From: [John Marks](#)
To: [Rebecka Groth](#)
Cc: [Doris Yau](#)
Subject: 3683 HAZARDS Review EIS, ARDEX Warehouse and Manufacturing Facility (SSD-25725029)
Date: Monday, 13 December 2021 2:06:50 PM

Thanks for forwarding the Environmental Impact Statement (EIS) for the ARDEX Warehouse and Manufacturing Facility (SSD-25725029). The proposed development is for the construction, internal fit out and operation of a manufacturing facility and warehouse. The facility is proposed to comprise manufacturing areas, warehousing, offices, powder silo and liquid tank storage. The proposal will have a capacity of 48,000 tonnes of powder products and 25,000 kilolitres of liquid products. Dangerous goods will be handled and stored at the proposed development.

Figure 3-1: Proposed Site Layout

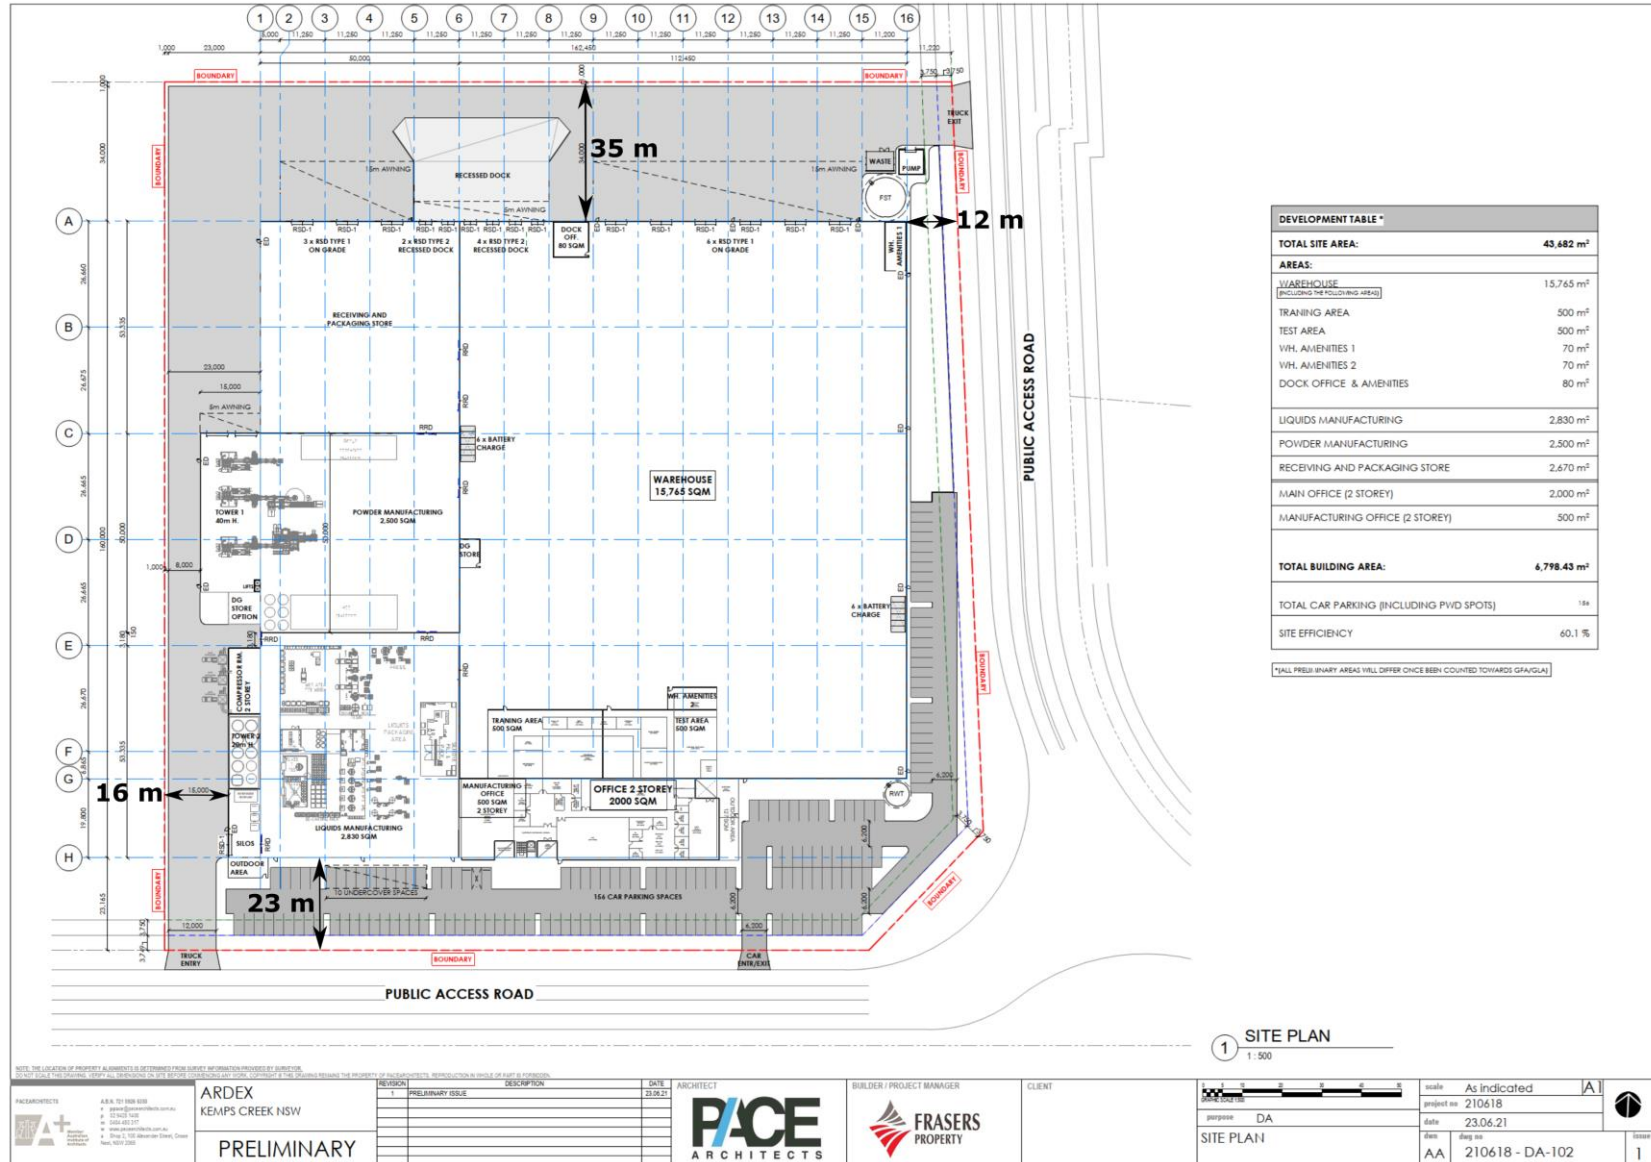
- a. The Department highlights that there were inconsistencies in separation distances used for preliminary risk screening of flammable liquids in the SEPP 33 Report. On page 6 of the SEPP 33 Report, describes 9 metres separation for risk screening of flammables. In Figure 3-1 of the SEPP 33 Report, the smallest distance is 12 metres to site boundary and in Figure 3-4, 16 meters separation is applied for preliminary risk screening. As such the Department is unclear on validity of the preliminary risk screening of flammable liquids given the smallest separation from the warehouse to the site boundary is 12 metres.;
